Application No: A/169/21/PL
Site Address: Land South Of Littlehampton Road and East of Worthing Road Angmering BN12 6PN
Description of works: Construction of a new access to serve existing agricultural use and proposed residential development. This site is in CIL Zone 5 and is Zero rated as other development. This application is a Departure from the Development Plan.

Sussex Area Ramblers Association
Planning Consultation Response
To Development Control, Arun District Council

Arun DC Planning Application A/169/21/PL
Angmering: Proposed access for development on Land south of Littlehampton Road, east of B2140 Old Worthing Road.

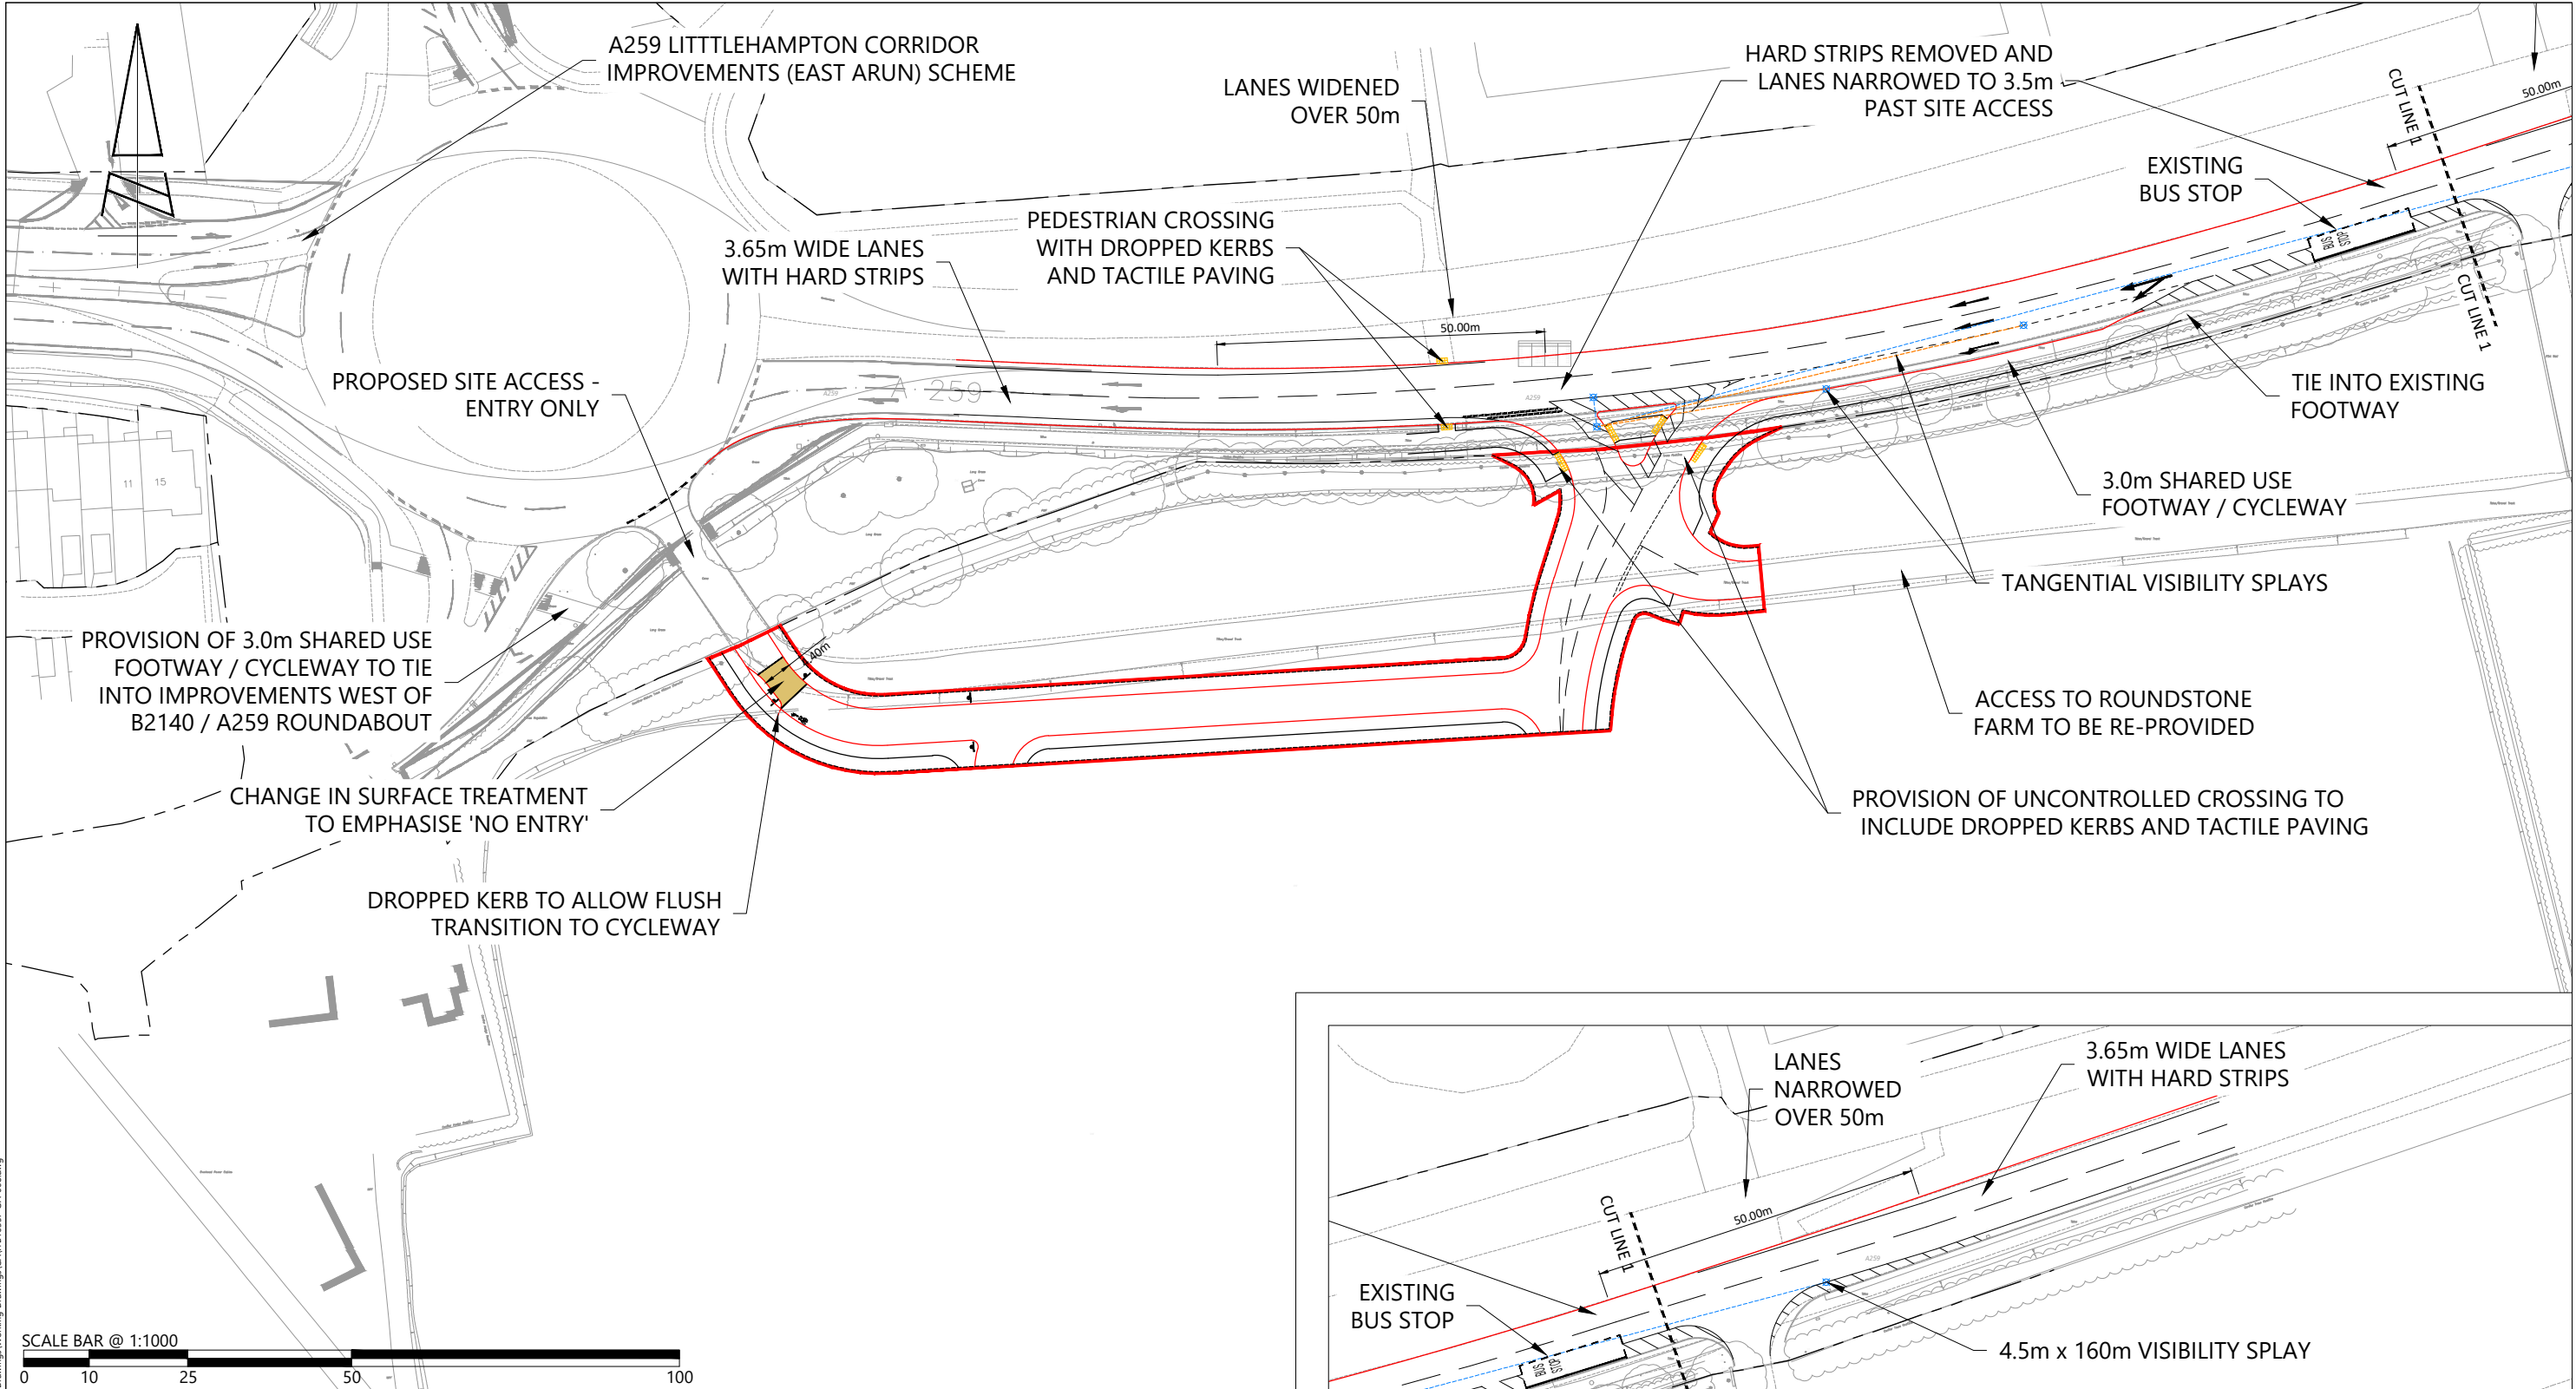
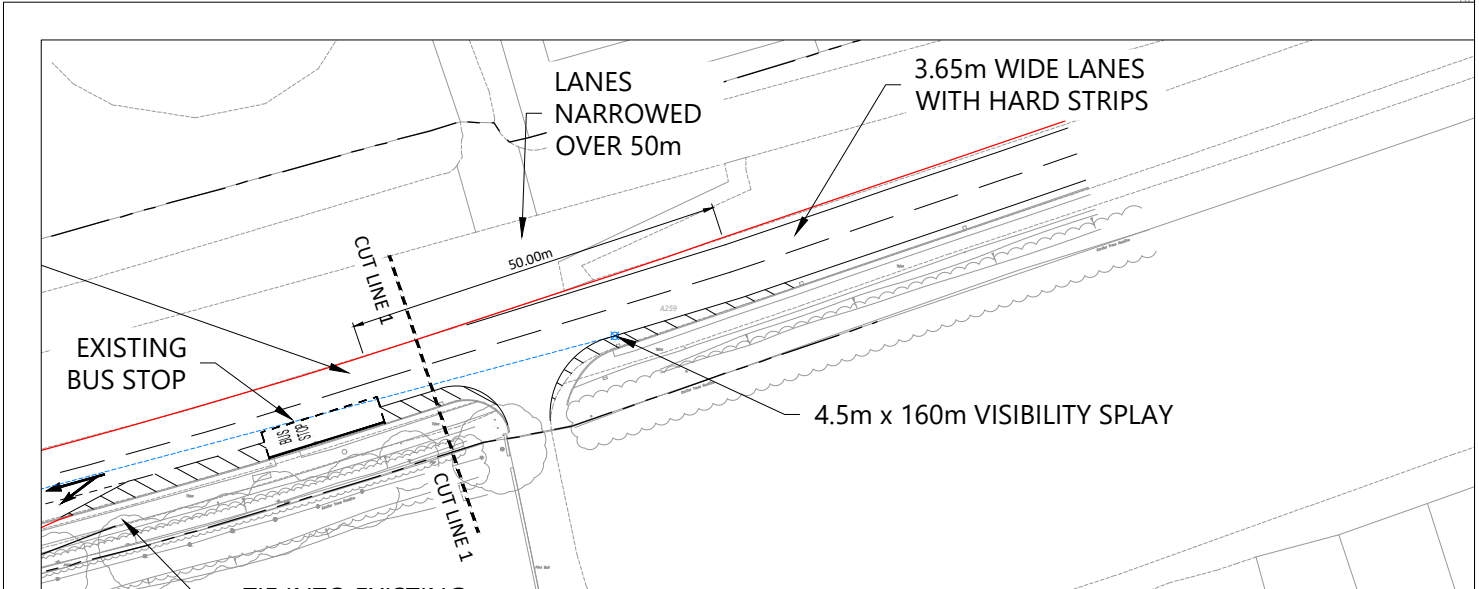
We object to the application because the proposed road junction will adversely impact the walking environment by physically and visually interrupting the pedestrian access linking FP2126 and FP2143 via the existing A259 footway.
